Walsall Council

Your Ref: TR050005
Email: planningpolicy@walsall.gov.uk
Telephone: 01922 658020
Date: August 2018
Please Ask For: Neville Ball

Planning Act 2008 (as amended) – Section 55
Application by Four Ashes Limited for an Order Granting Development Consent for the West Midlands Interchange
Adequacy of consultation request

Drawing Title Drawing Size A1
 ILLUSTRATIVE MASTERPLAN WEST RAIL OPTION

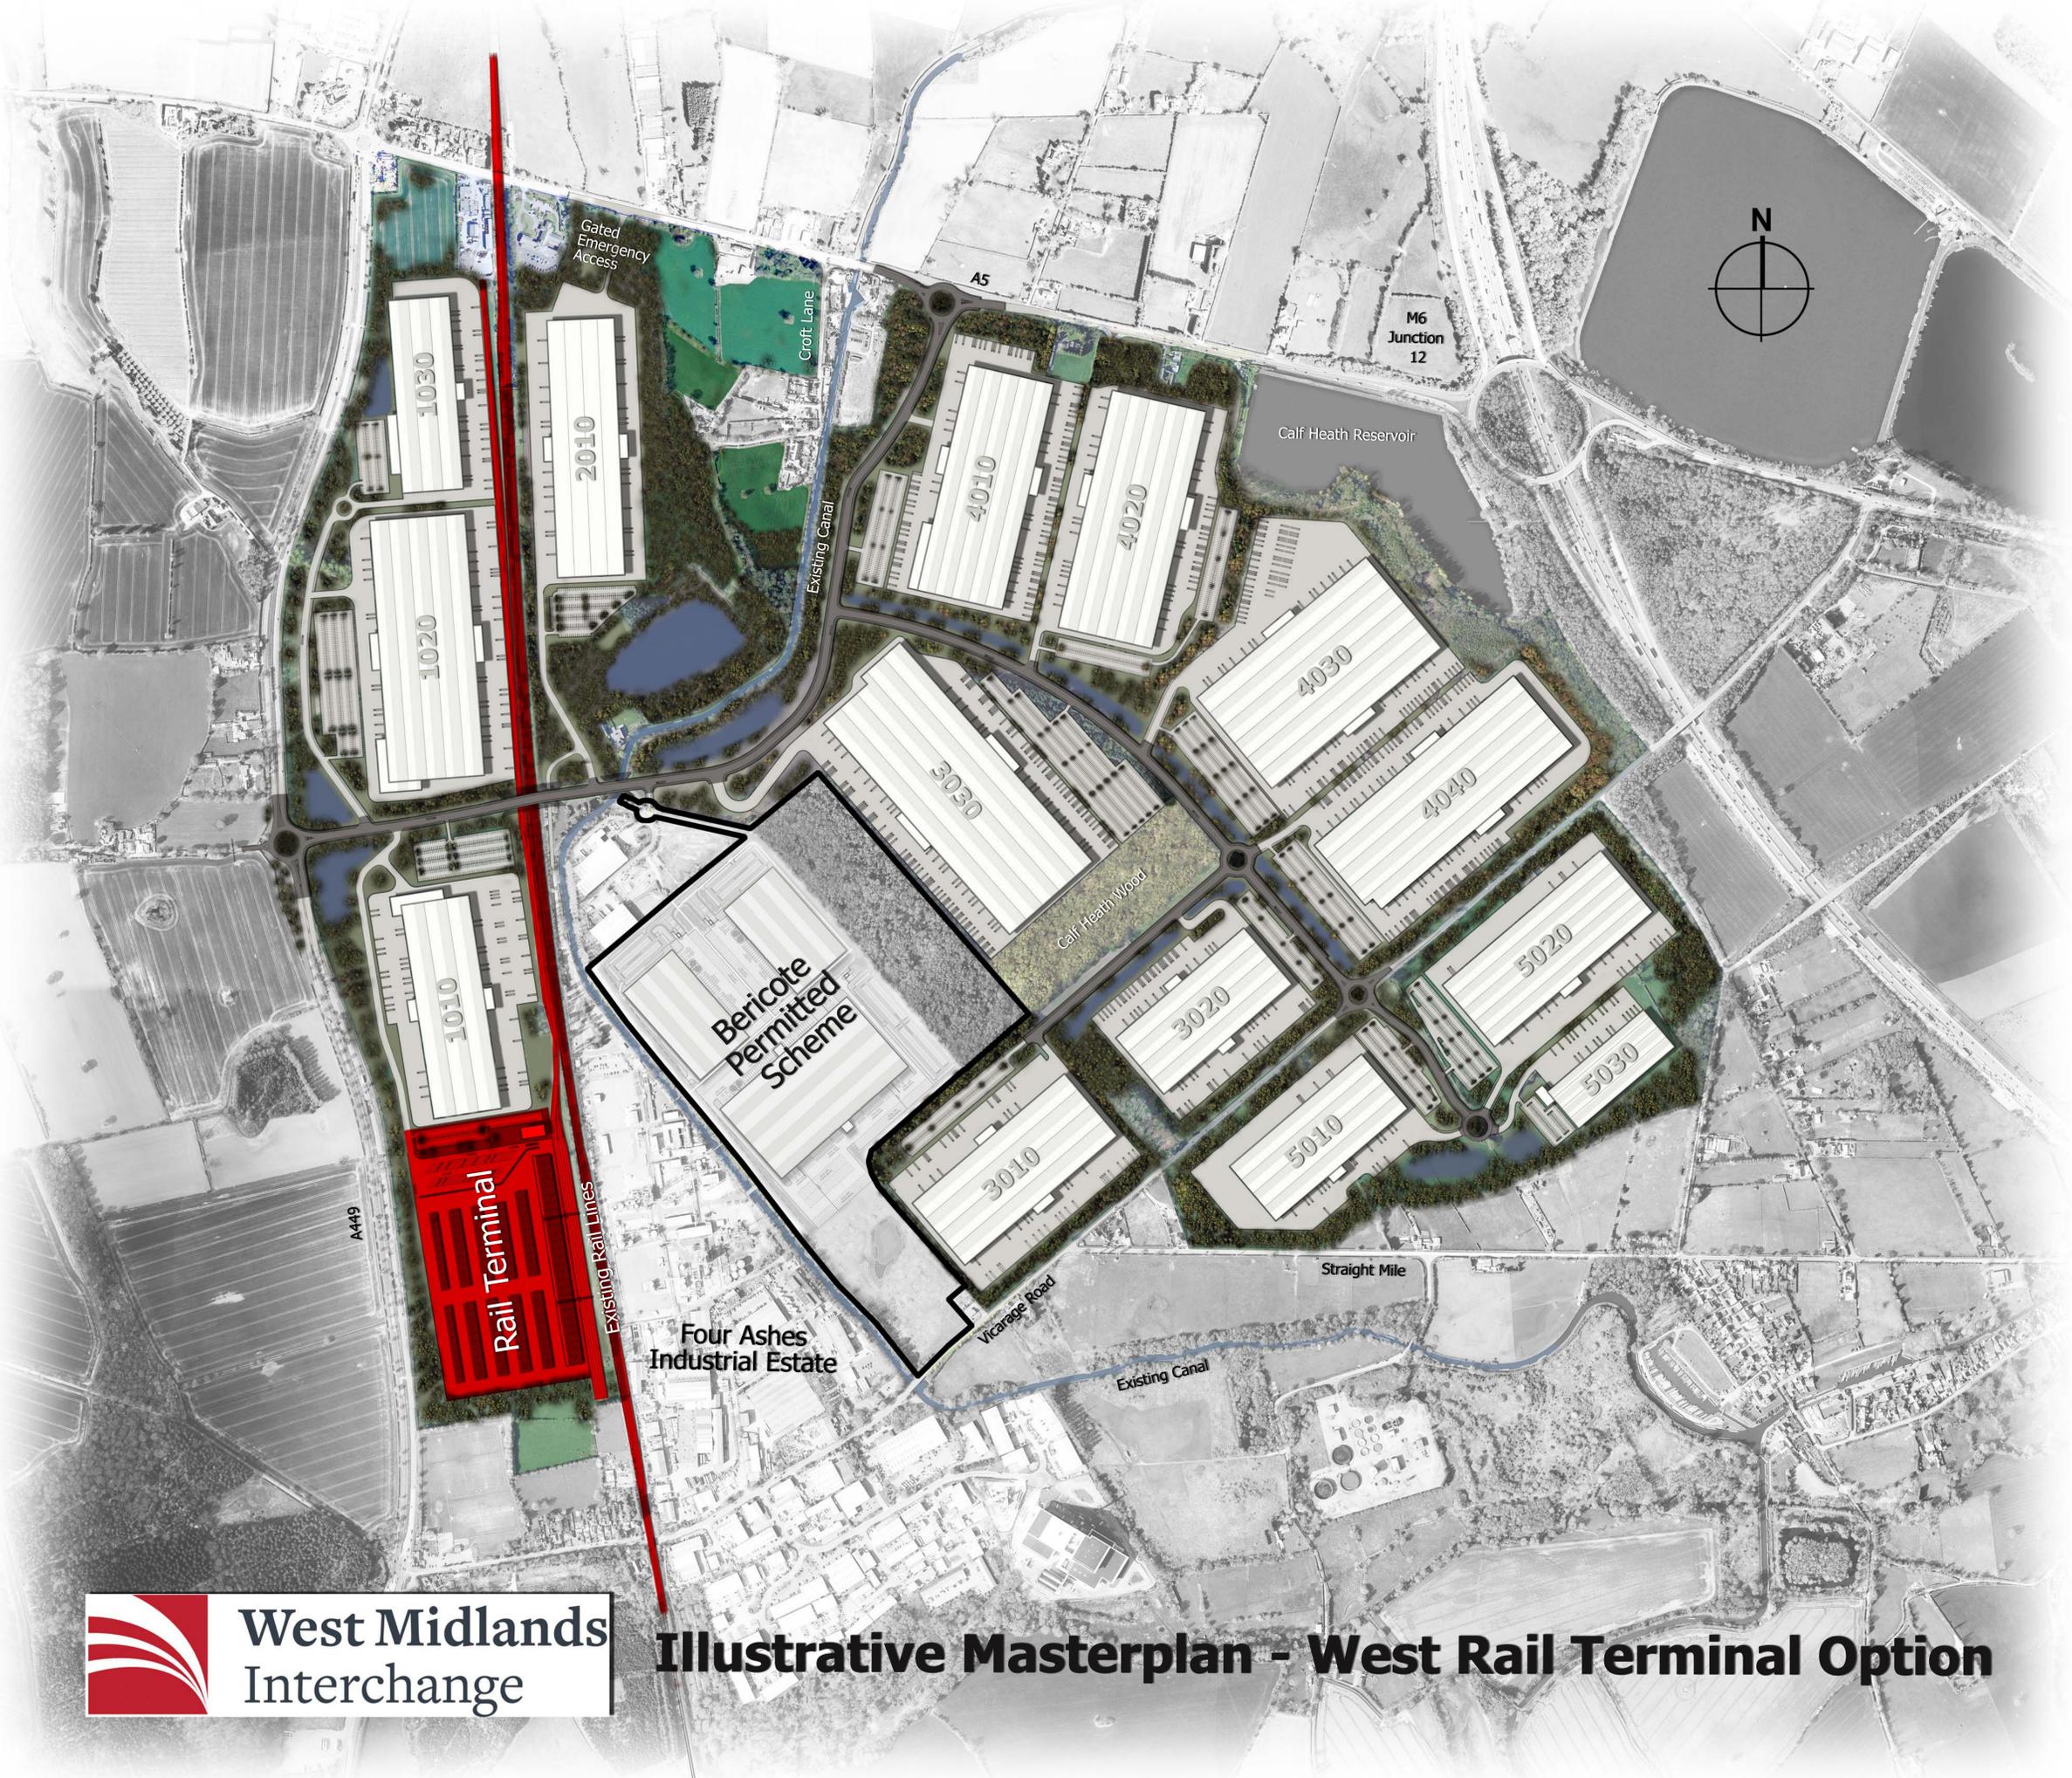
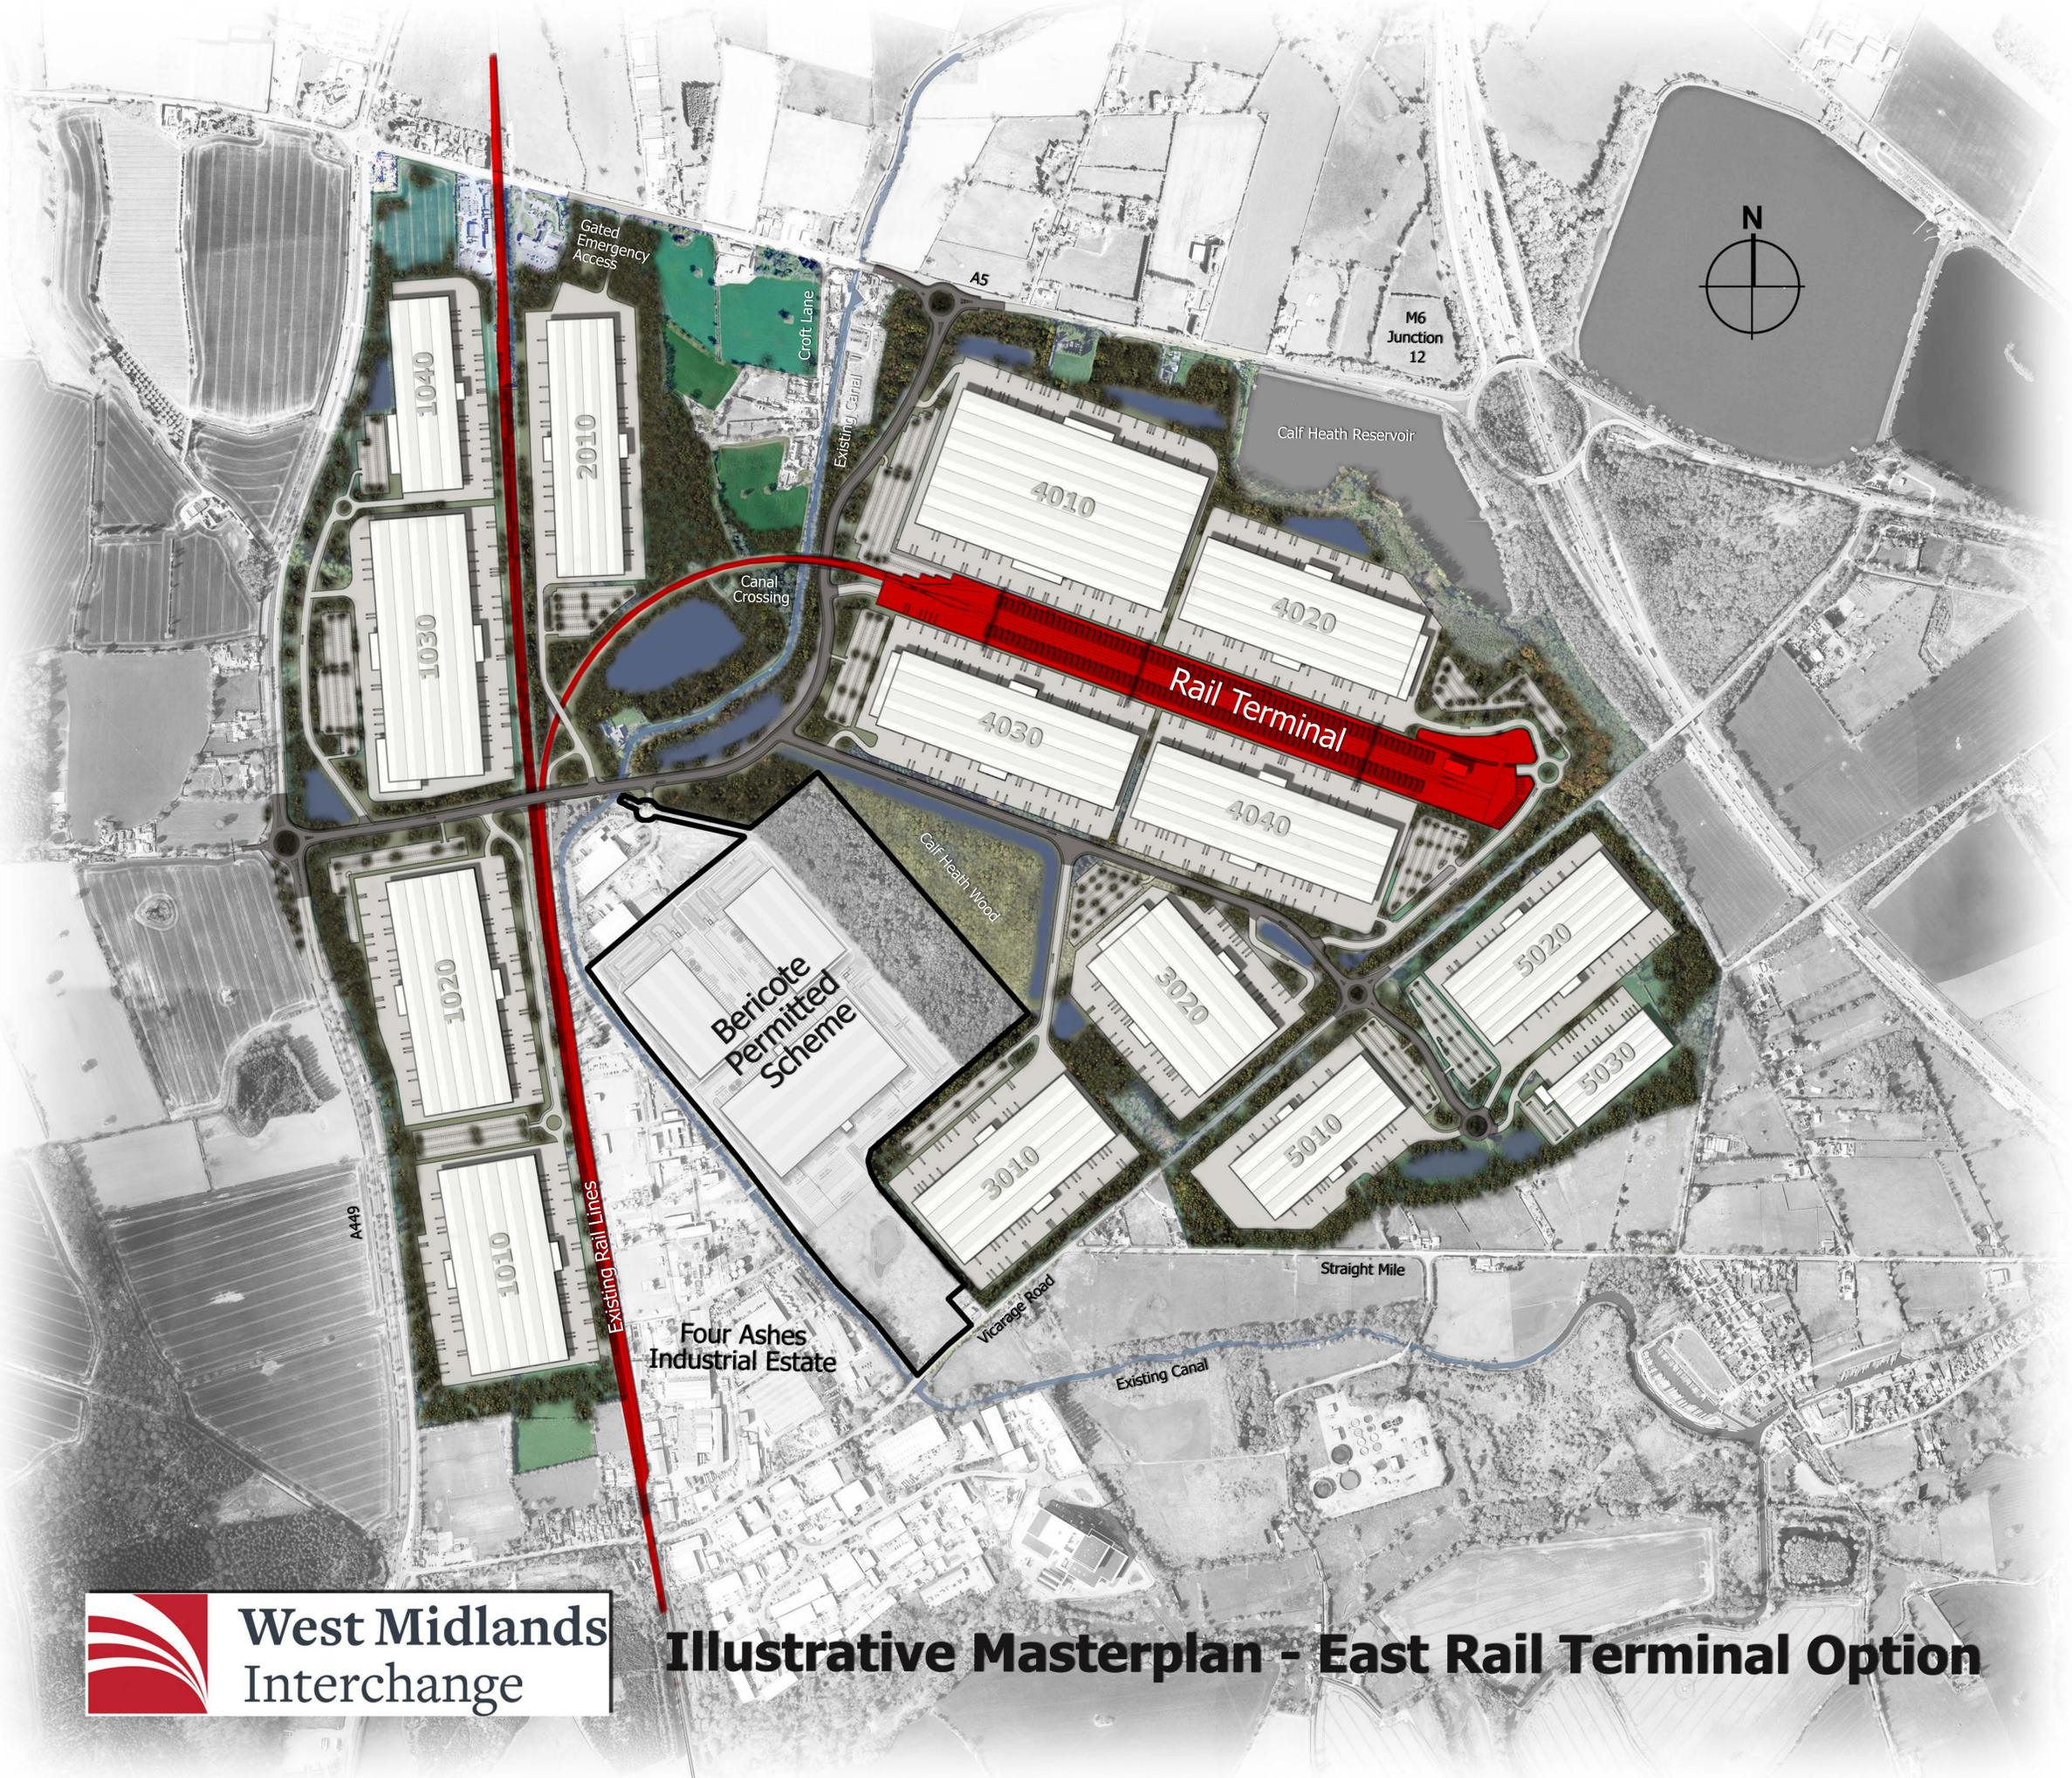
As an aside, there would appear to be a significant error in the illustrative masterplan (<http://www.westmidlandsinterchange.co.uk/wp-content/uploads/2016/12/December-2016-Illustrative-Masterplan.pdf> and reproduced elsewhere in the documentation). The floor areas of the individual buildings appear to be shown in square metres but appear to be missing a '0'. The buildings shown as 1010 should in fact be 10,100 etc. Although the total size of the proposed development is stated elsewhere in the documentation (700,000m²), this error could give a misleading impression of the scale of the buildings, especially since the supporting documentation claims that a major justification for the development is a current shortfall in class B8 buildings of over 100,000ft² (9,200m²).
